Application by Tillbridge Solar Limited for Tillbridge Solar Project
The Examining Authority's first written questions and requests for information (ExQ1)
Issued on 19 November 2024

Responses are due by Deadline 3: Tuesday 10 December 2024

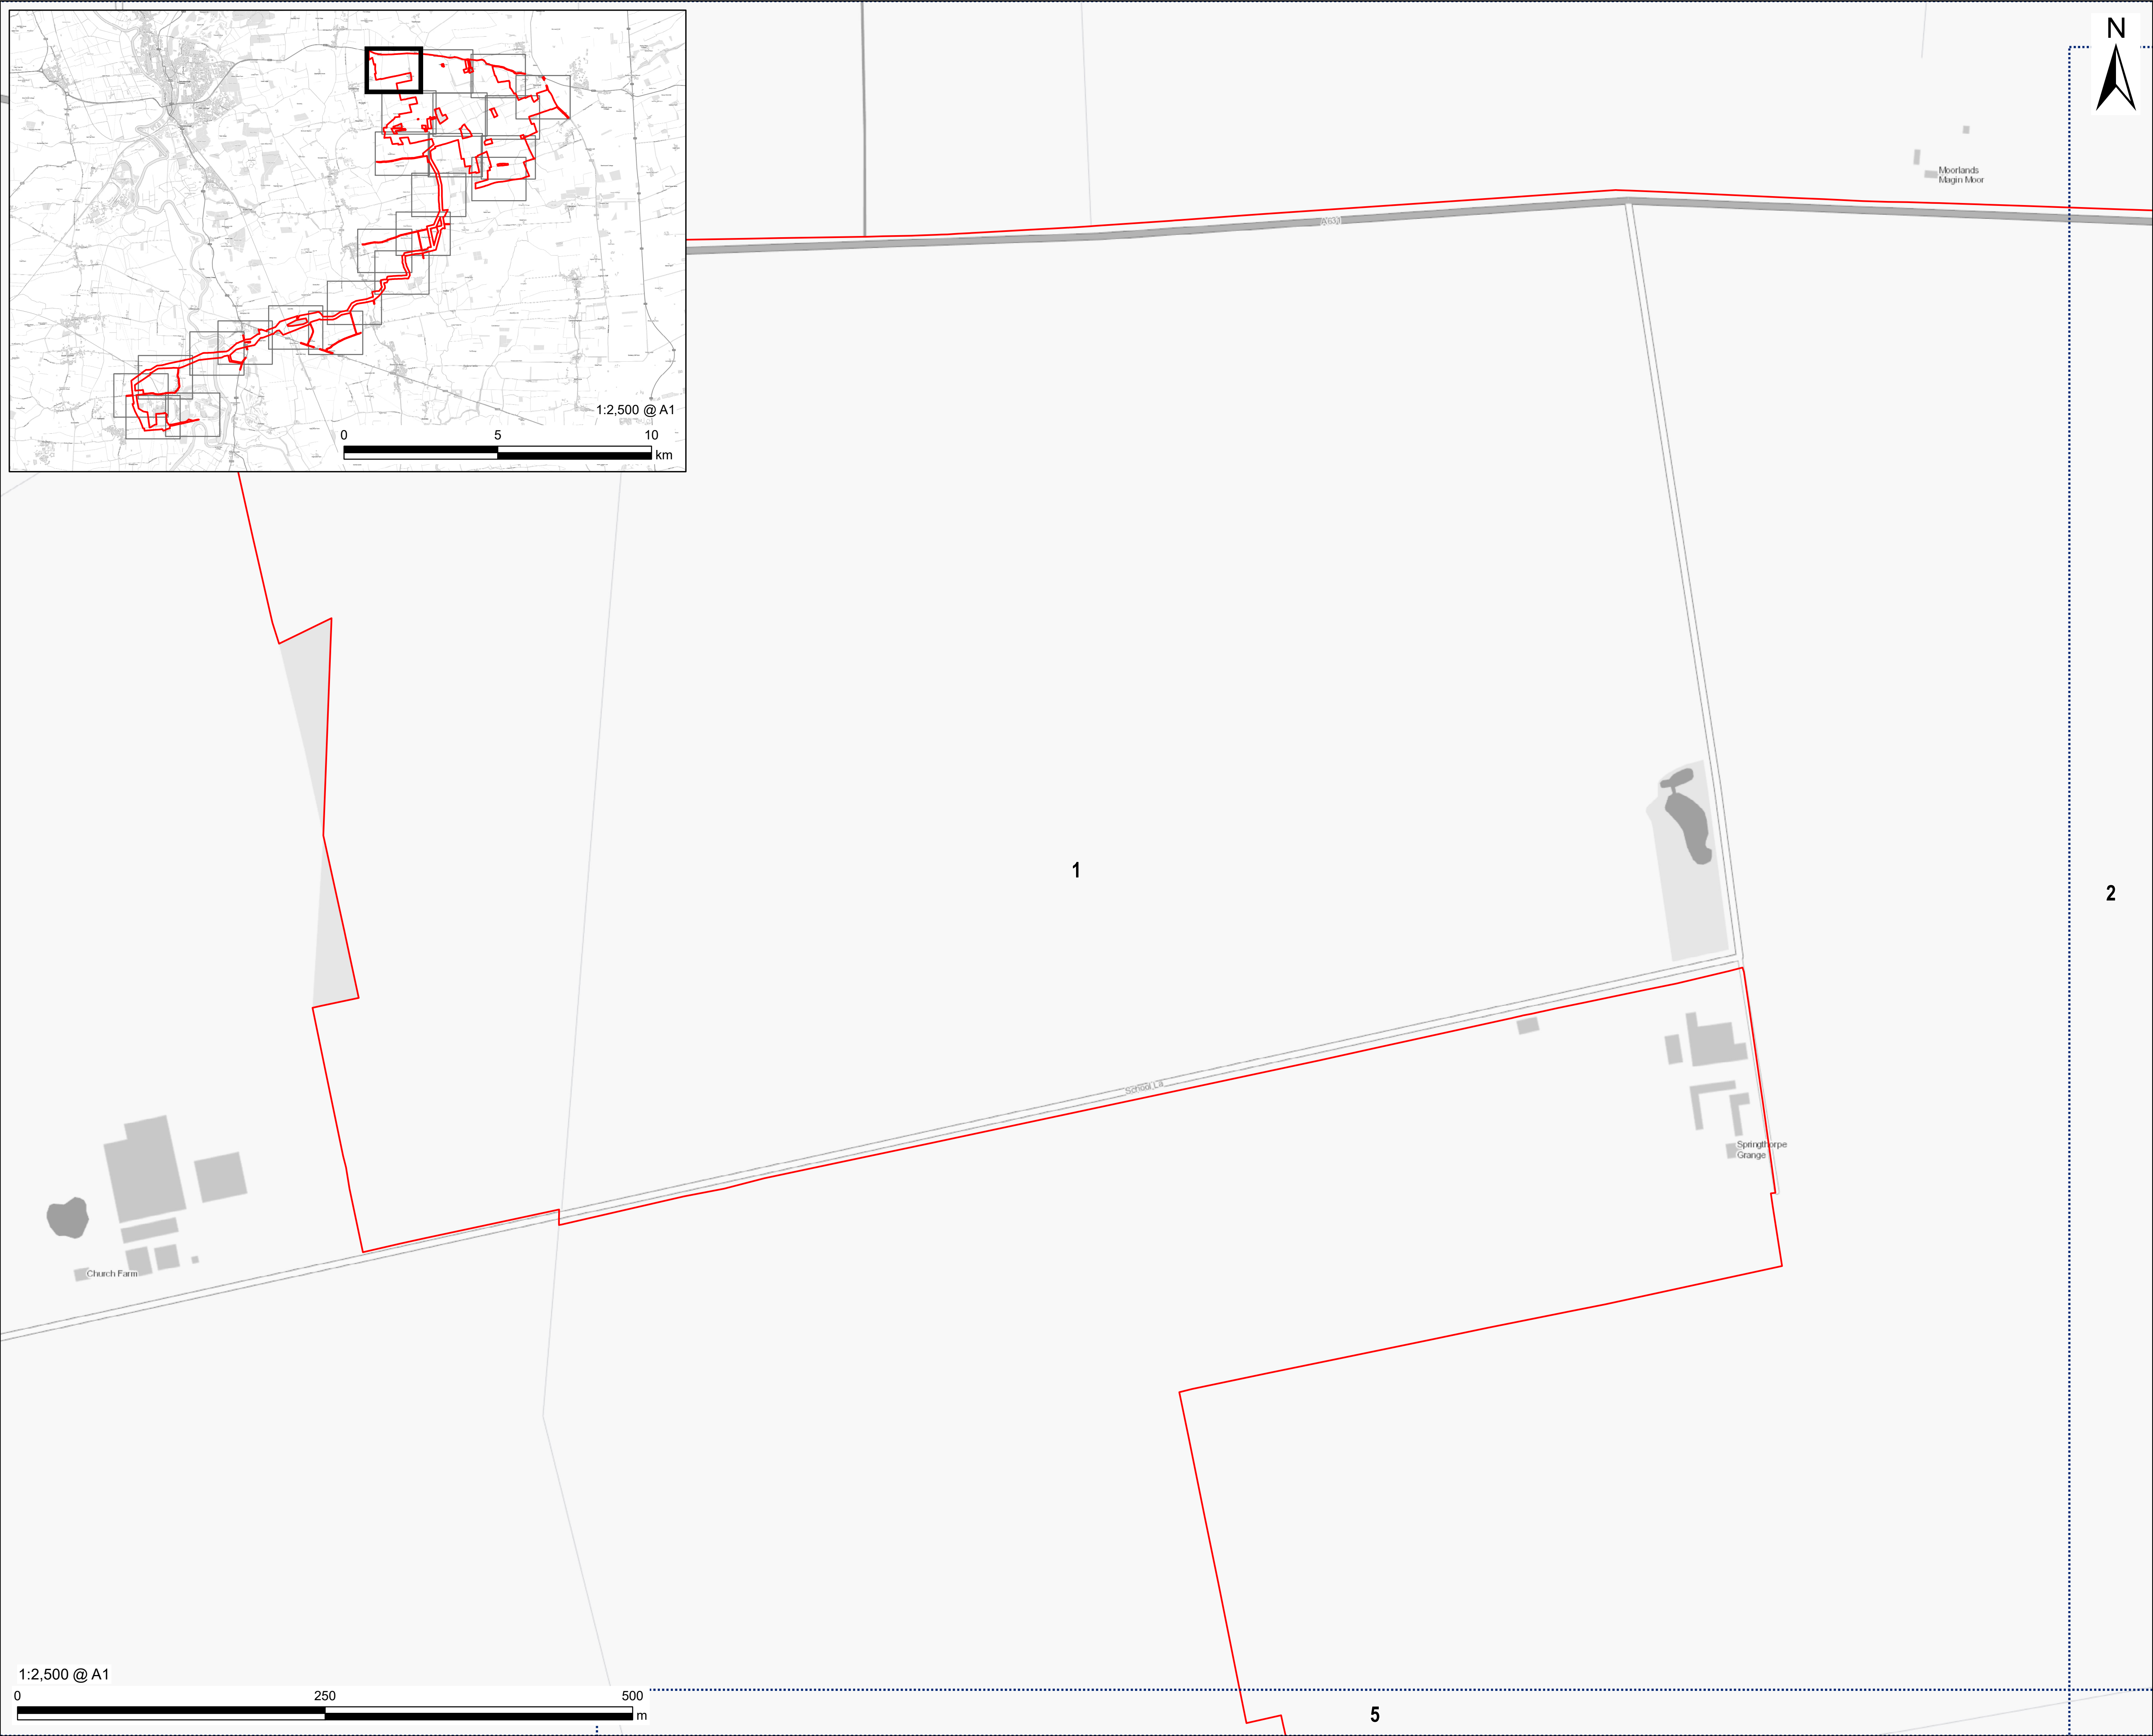
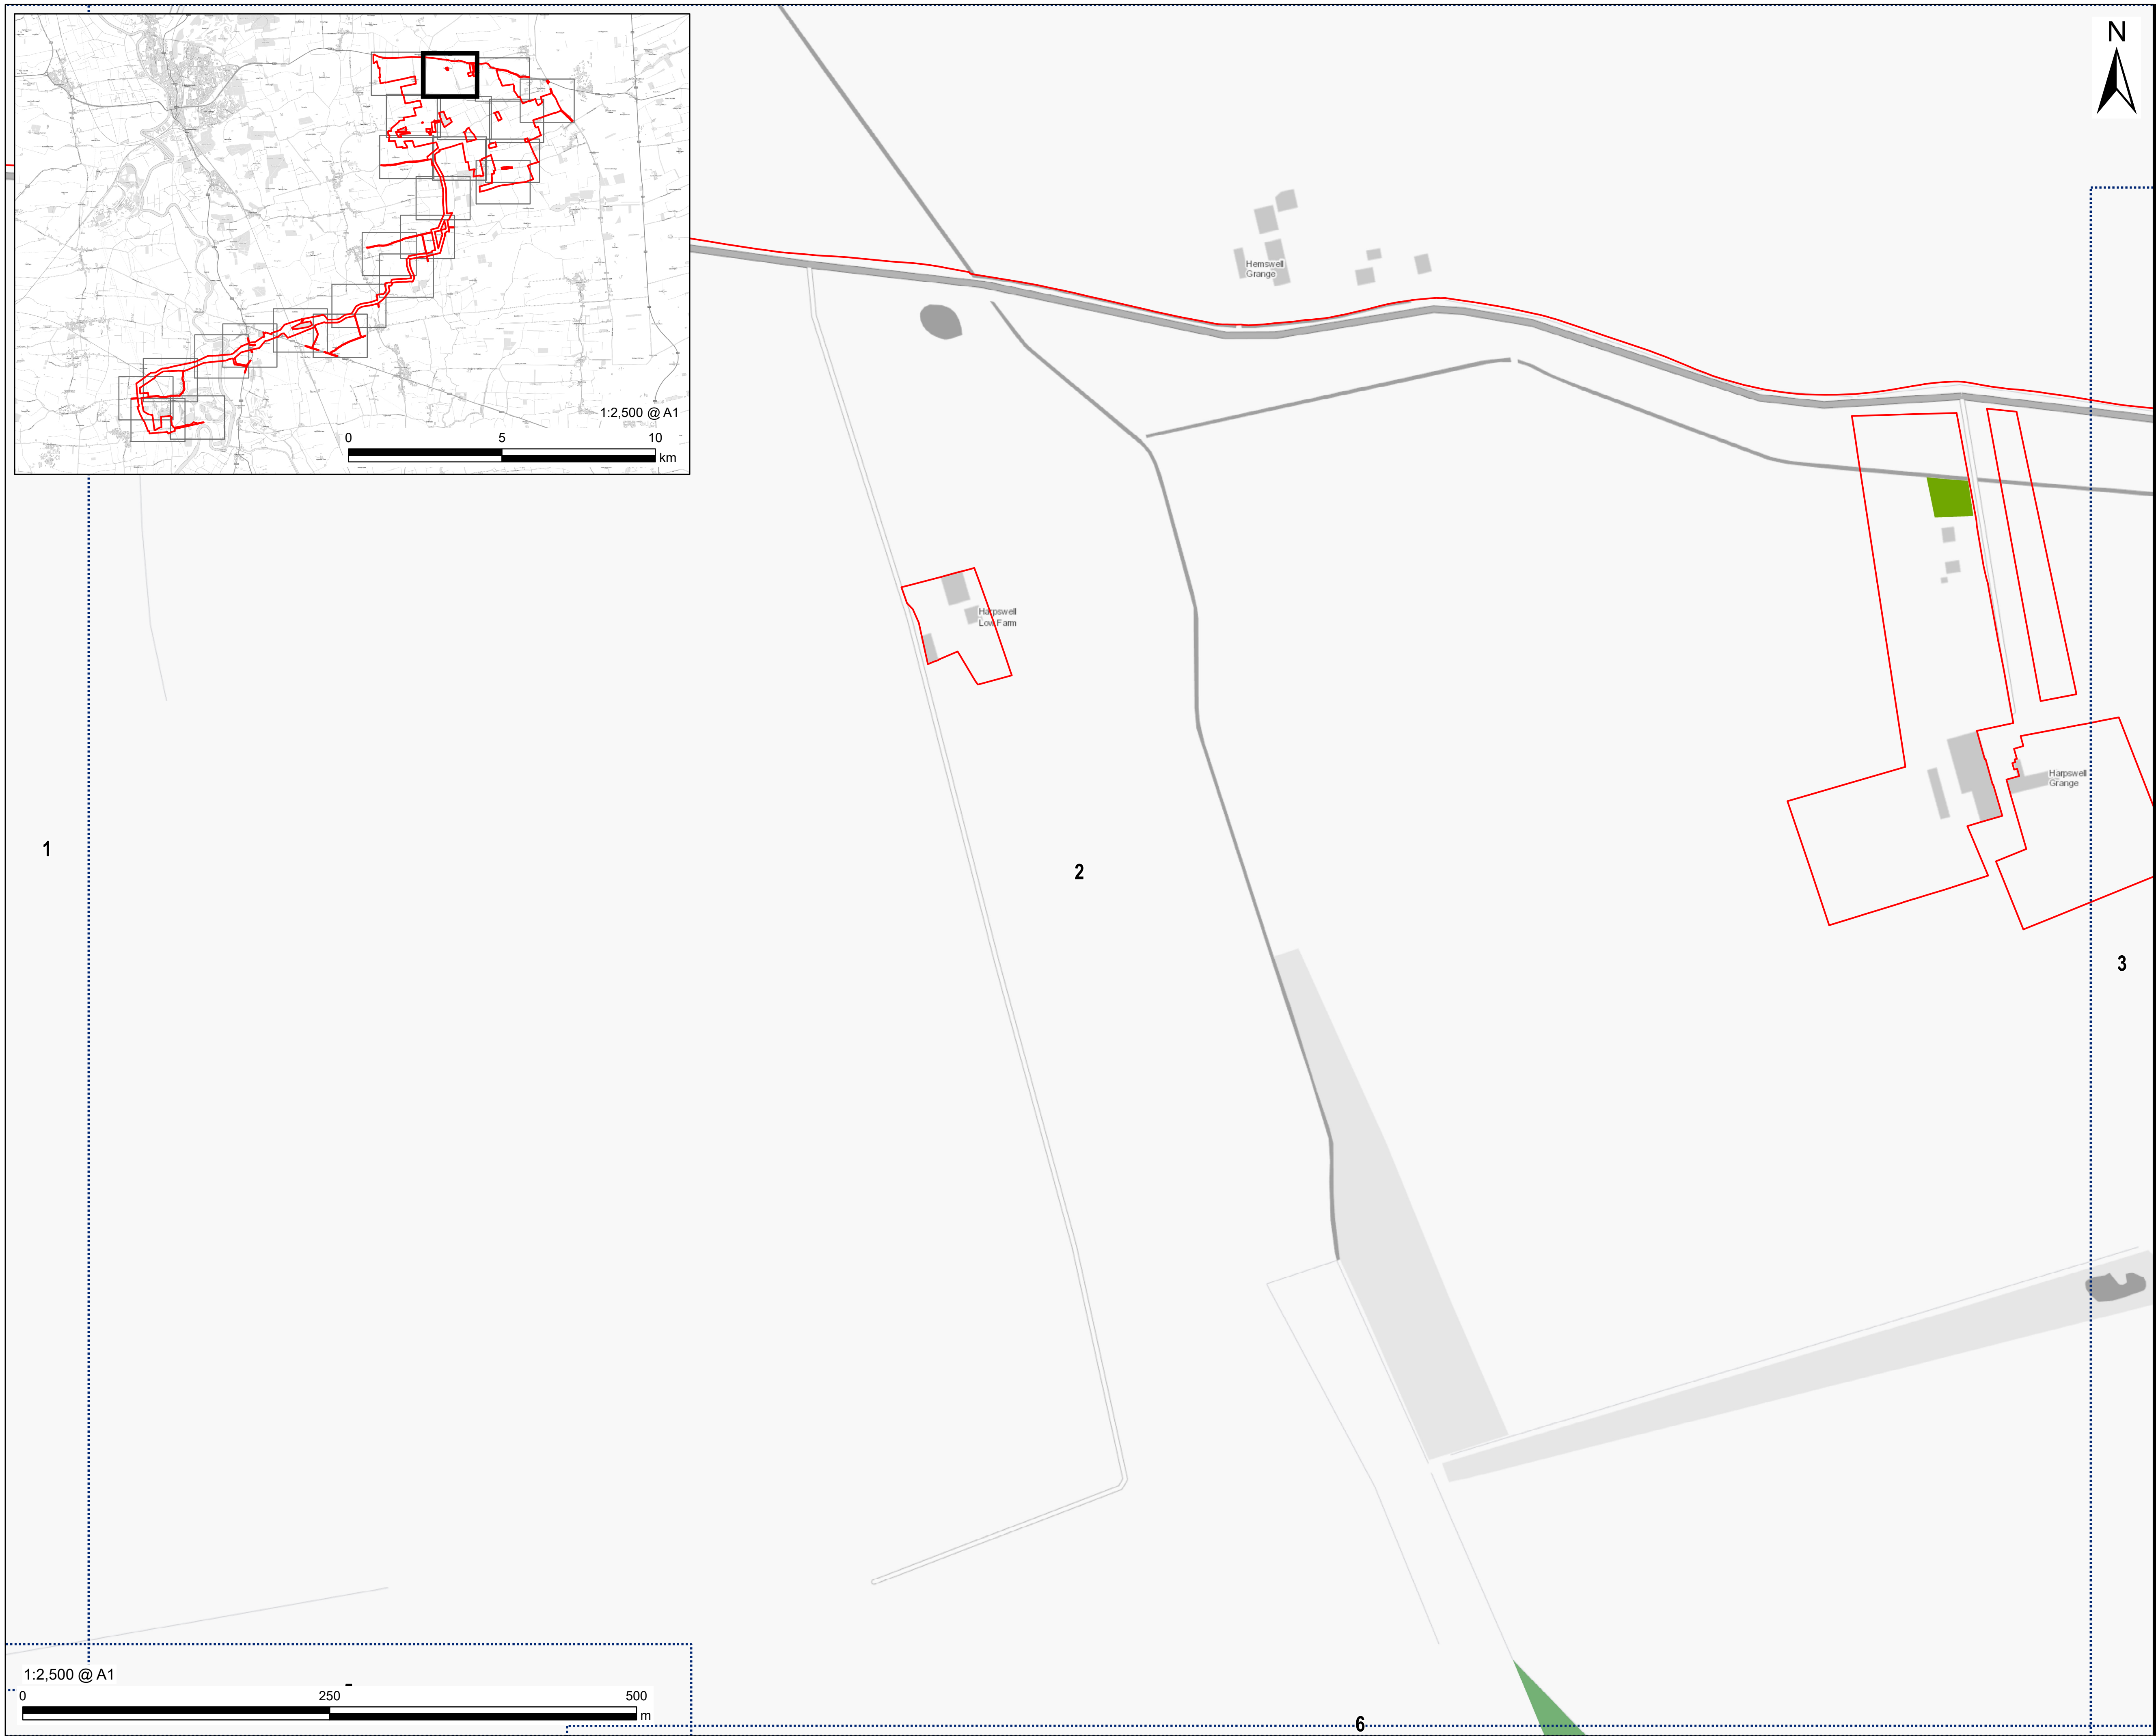
ExQ1	Question to:	Question:
		<p>please provide an updated copy of the phase 1 habitat maps depicted in ES Figure 9-3 [APP-166] which do not identify any target notes.</p> <p>Also please provide a plan demonstrating how the risks of a bentonite breakout during directional drilling would be managed and controlled.</p>
Habitats Regulations Assessment (HRA)		
Q1.2.14	Natural England	<p>HRA</p> <p>Does Natural England (NE) have any representations in relation to the Applicant’s responses to Natural England’s Relevant Representation [RR-208] provided in the document titled ‘Applicant’s Responses to Relevant Representations’ (PDF pages 10-28) [REP1-028]? Could NE also please provide a response on updated ES Appendix 9-12: Habitats Regulations Assessment Report [REP1-058] and in particular the conclusions in relation to:</p> <ul style="list-style-type: none"> a) the distances used to screen in European sites to the assessment; b) the rationale for screening out the Golden Plover qualifying feature of the Humber Estuary Ramsar site; c) conclusions in relation to no Likely Significant Effects (LSE) from water quality to the Humber Estuary Ramsar site and Humber Estuary Special Area of Conservation (SAC); and d) the conclusions in respect of in-combination effects with the One Earth Solar and Great North Road solar projects.
